**From:** Contact Centre (CRM) <contact@ribblevalley.gov.uk>  
**Sent:** 19 December 2024 09:36  
**To:** Planning  
**Subject:** Planning Application Comments - 3/2021/0275 FS-Case-671781106

**Planning Application Reference No.:** 3/2021/0275

**Address of Development:** Land Behind The Dog Inn Market Place Longridge PR3 3RR

Proposed Site Plan
1 : 200
0 1 5 10m

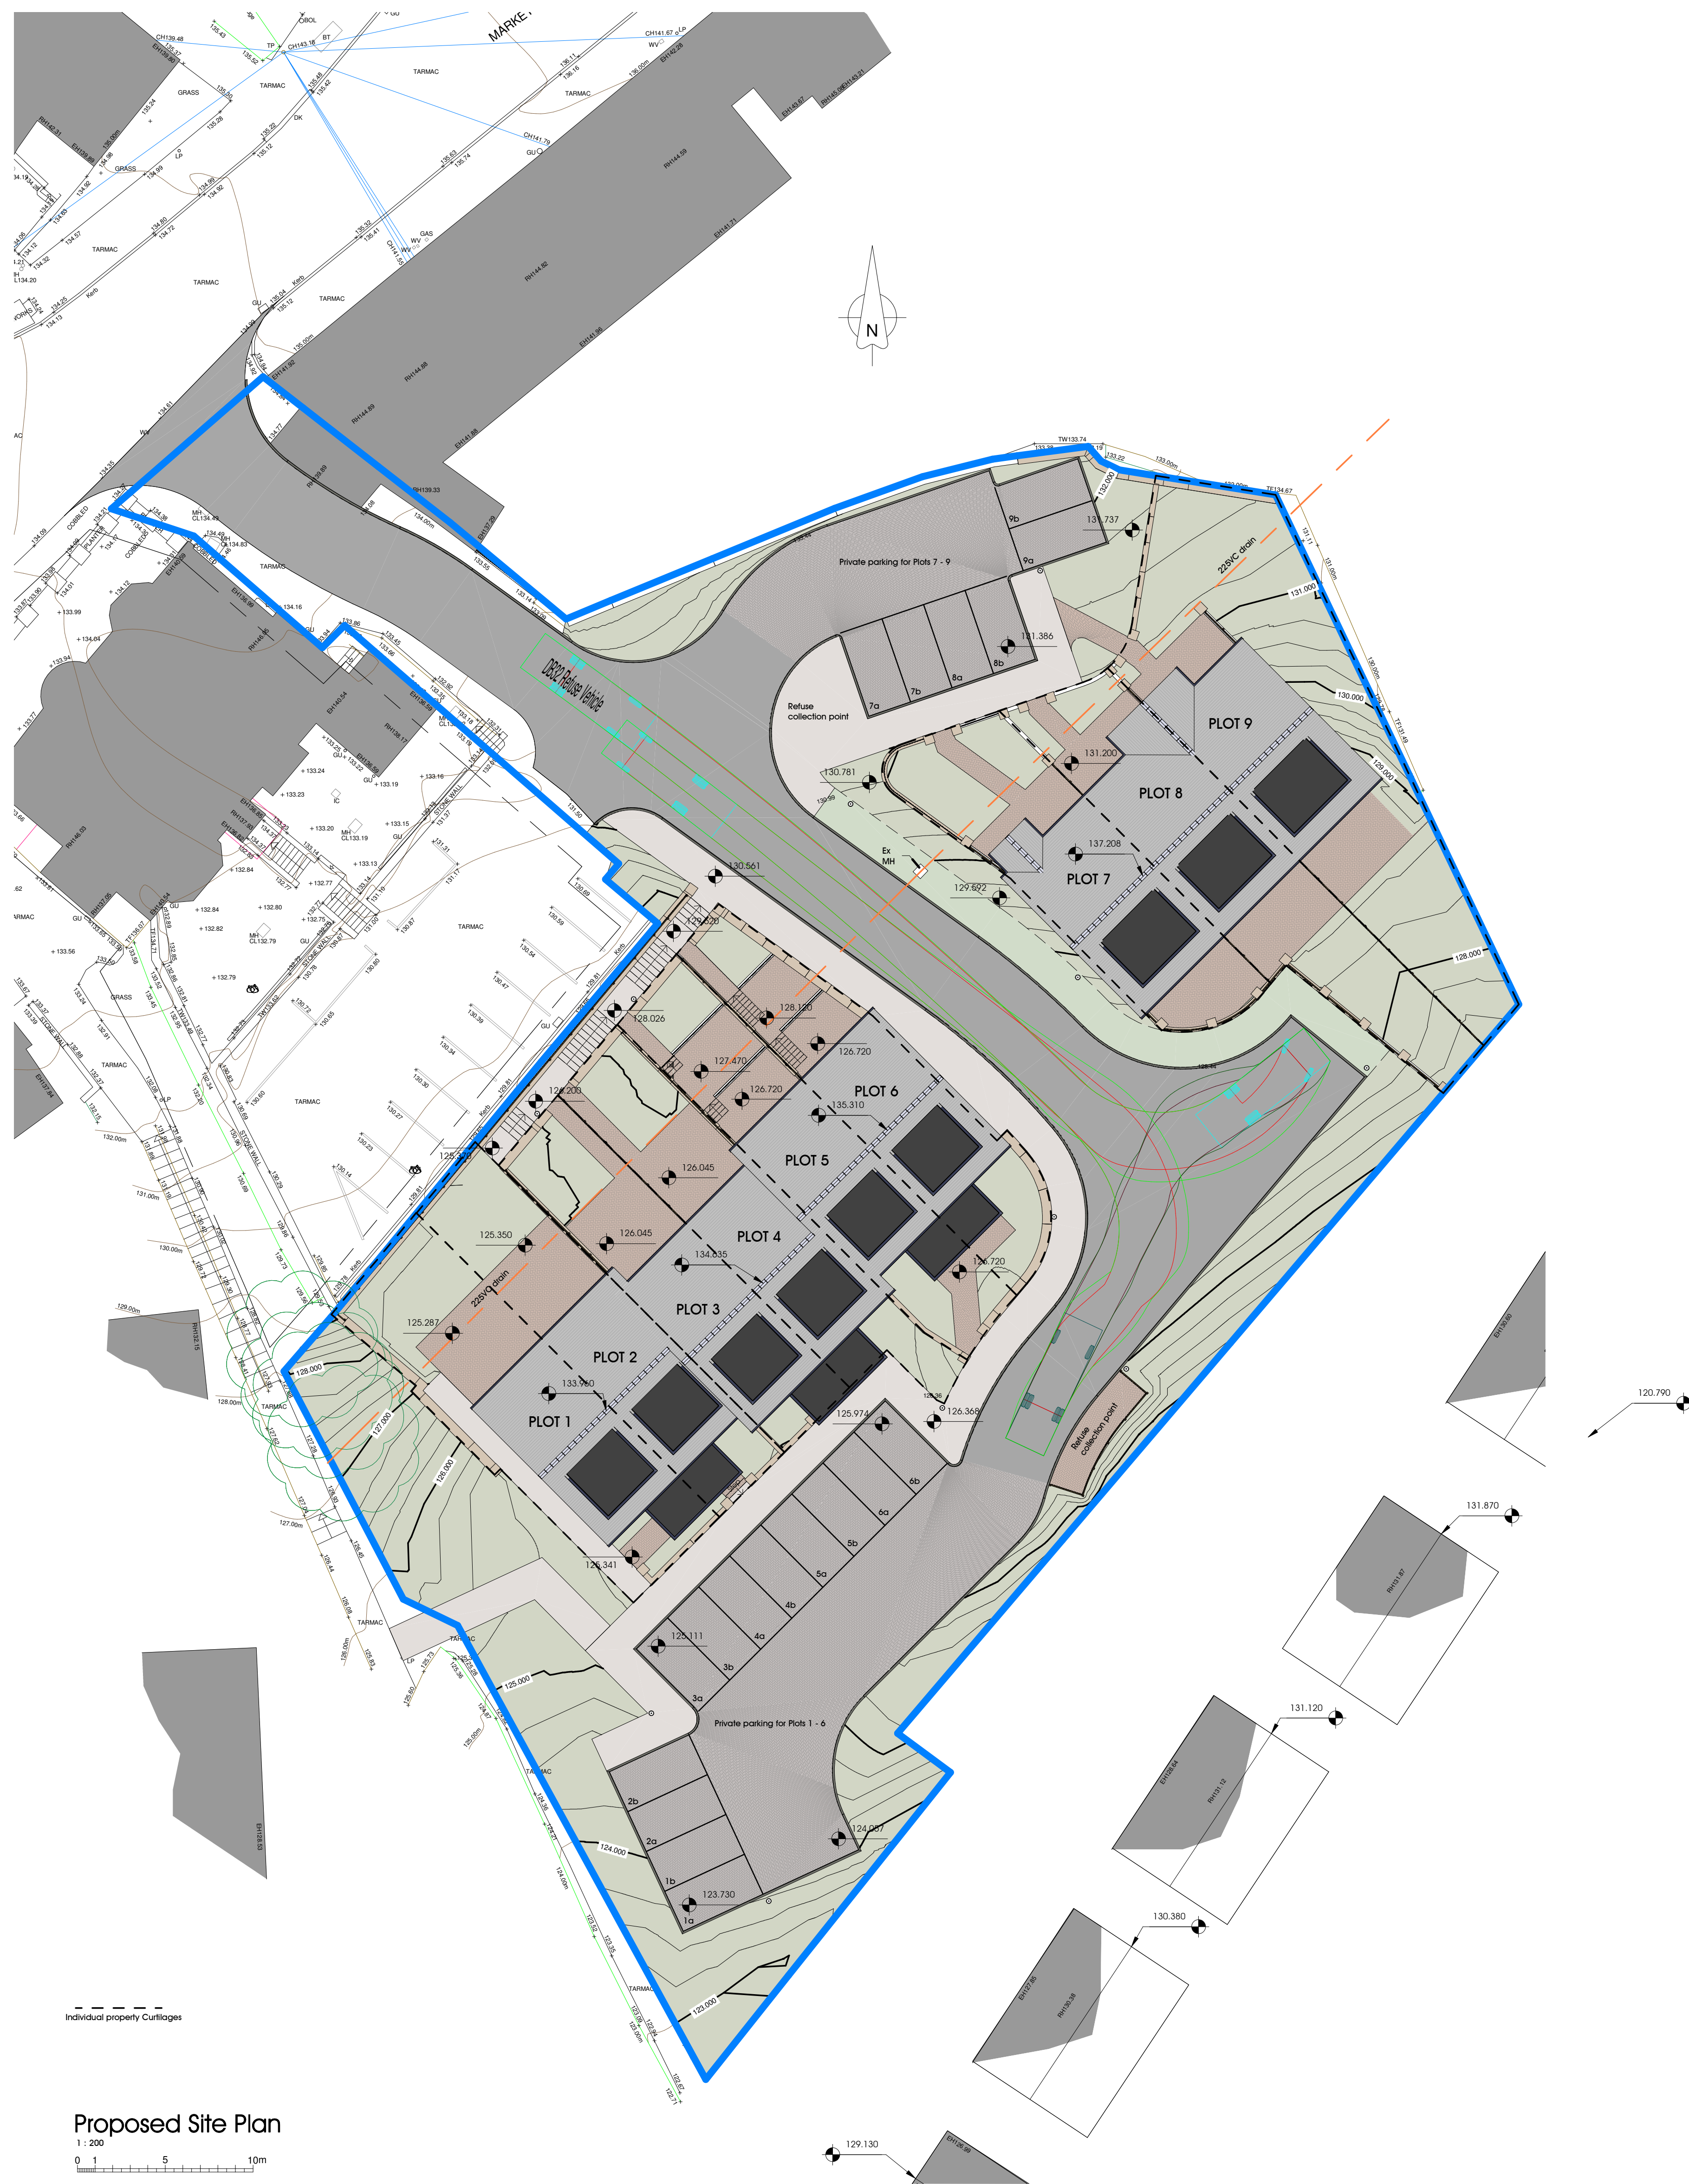
**Comments:** Apologies for missing the deadline to reply - [REDACTED]  
[REDACTED]. I have concerns regarding surface water drainage as a result of this development. Plans state surface water will run to the existing manhole to the west of the site. The increase in surface water to this area due to the development will create excess water to the west of the site, and thus in the direction [REDACTED]. [REDACTED] path in which the manhole is close to. It is lower down than the manhole therefore water [REDACTED] [REDACTED] risking flooding. I am seeking professional opinions from drainage experts regarding this issue and am not satisfied that the current plans have taken into account the effect the development would have on properties below with regards to surface water.
